WEST SUSSEX COUNTY COUNCIL CONSULTATION

TO:	Arun District Council FAO: Anita Gardner
FROM:	WSCC - Highways Authority
DATE:	29 November 2019
LOCATION:	6 Manor Road Rustington BN16 3QT
SUBJECT:	R/268/19/PL Demolition of existing garage & store on existing dwelling & erection of 1 no. four-bed chalet style dwelling (re-submission of planning ref: R/72/19/PL).
DATE OF SITE VISIT:	n/a
RECOMMENDATION:	Advice
S106 CONTRIBUTION TOTAL:	n/a

DRAWING: PROPOSED ELEVATIONS - DWELLING AND DETACHED GARAGE

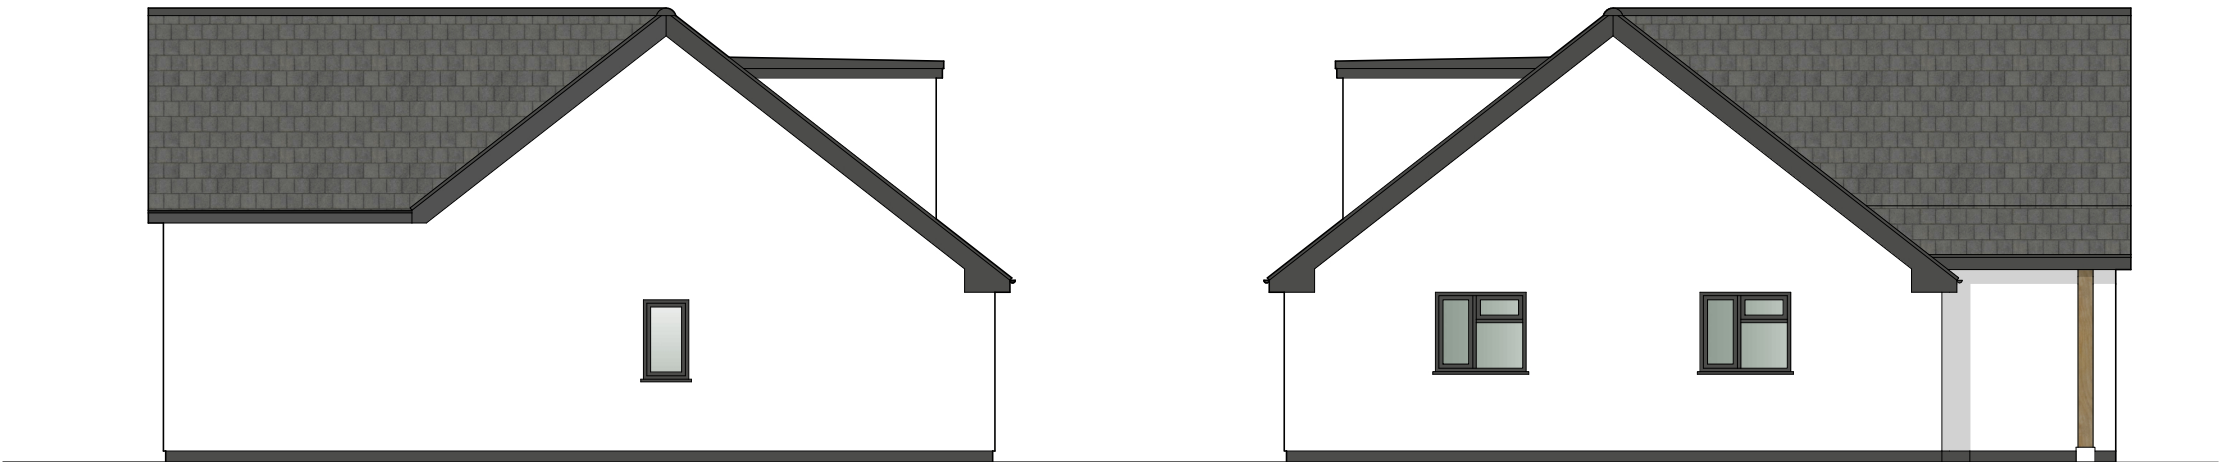
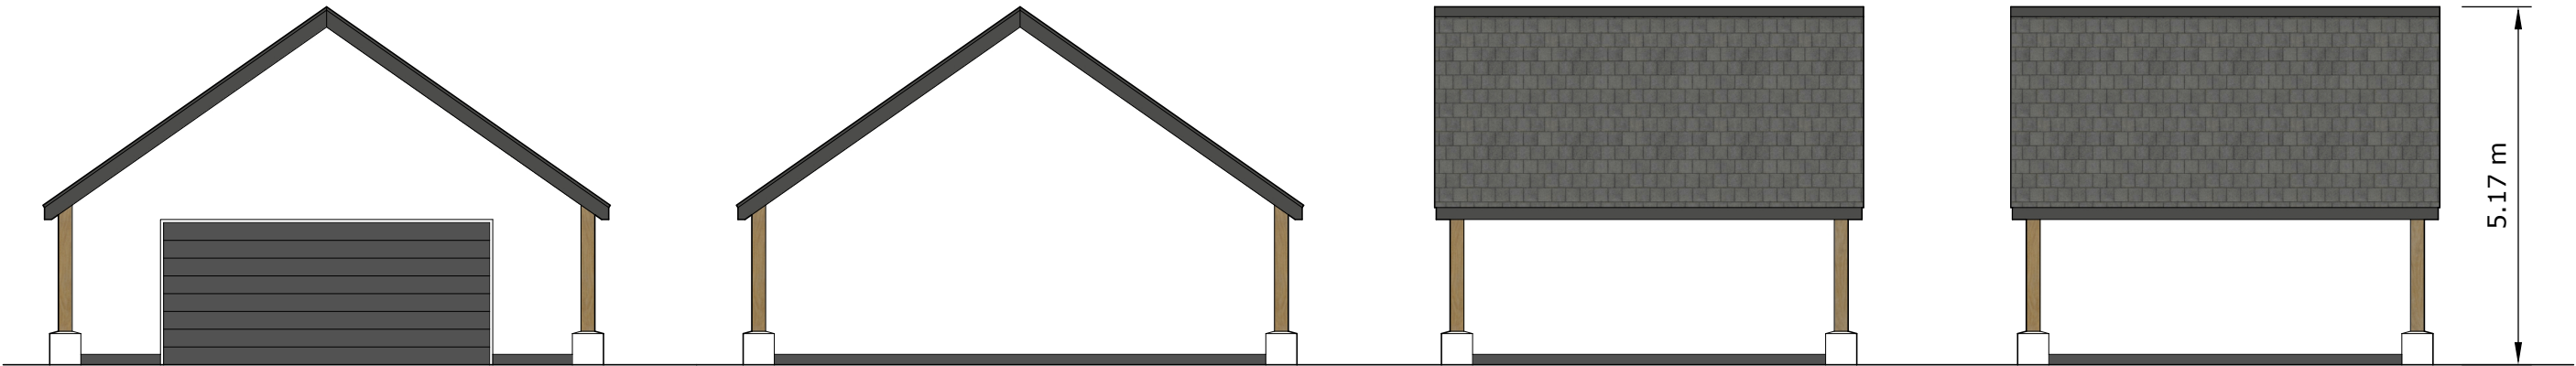
The applicant will provide a garage (8 x 6 metres) large enough to accommodate a parking provision for 2 cars as per the WSCC guidance for a dwelling of this size and location.

As per Plans titled *Proposed New Dwelling* and dated 30/10/2019, cycle parking will be provided in the newly proposed 2 bay garage. This conforms to requirements set out by Manual for Streets (MfS) and WSSC guidance for Covered/Lockable storage.

Fig 4. Extract from Proposed Site Plan

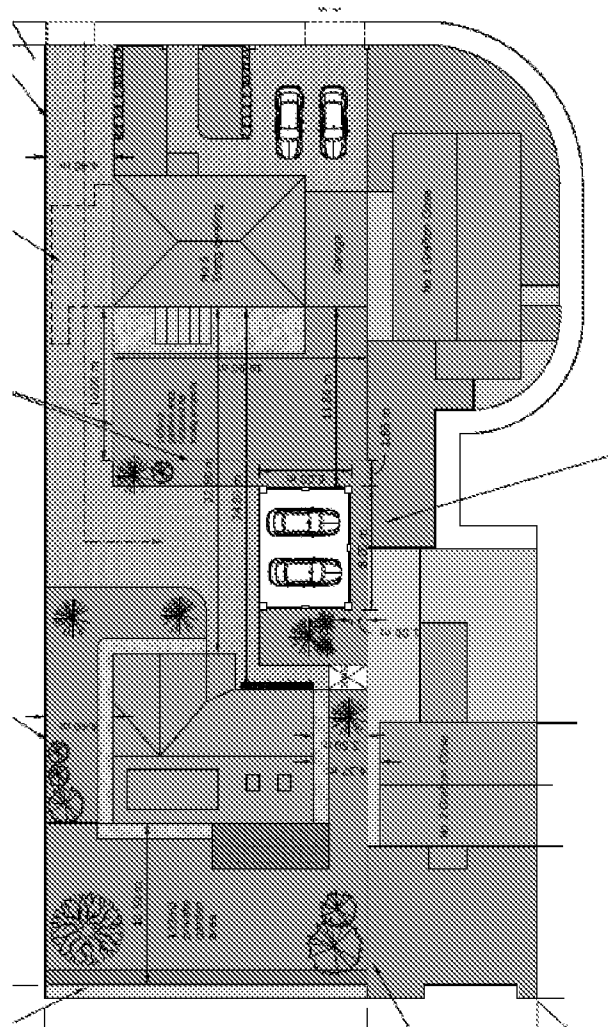
The applicant proposes to widen the boundary treatment at the Eastern and Western access point onto Manor Road without extending either Vehicle Crossover (VCO) to reflect such amendments. The LHA advise that the applicant widens both VCO's so 'bumping' the curb does not become practice. This would be particularly relevant for eastern access point due to the proposed parking arrangement of two hardstanding spaces side by side. I note this access point is included within the red edge on the location and block plan, but not on the proposed site plan. Any widening works should

The applicant has not demonstrated the boundary treatment details at the western access point segregating the proposed and existing dwellings. The Applicant should be made aware that visibility must be maintained at this point. A 2 metre set back with a maximum height of 0.6 metres distance should be maintained at all times, to ensure future occupiers have the ability to enter the publicly maintained highway in a safe manner.

The dwelling is a minimum of 50 metres away from Manor Road. Consideration at the planning stage needs to therefore be given to emergency access and refuse collection in order to satisfy building regulations. There is no indication of any waste storage or collection points on the proposed site plan. The LPA would be advised to consult with the waste collection authority to determine the suitability of any waste collection point. It should be noted that if the preferred method of refuse collection is at the site access point onto Manor Road then the waste carry distance for residents would be in excess of the maximum distances as described in Manual for Streets 6.8.9 (carry distance 30 metres / collection distance 25 metres).

The submitted plans show an area located to the southwest of the garage maybe used as a turning area. This area measures 3.4 x 3 metres. This is below the WSCC and Manual for Streets (MfS) recommendation of 6 metre depth for a turning area. It should be noted however that occupiers of this development would still be able to make a multiple point manoeuvre within the site though this is not the preferred practice.
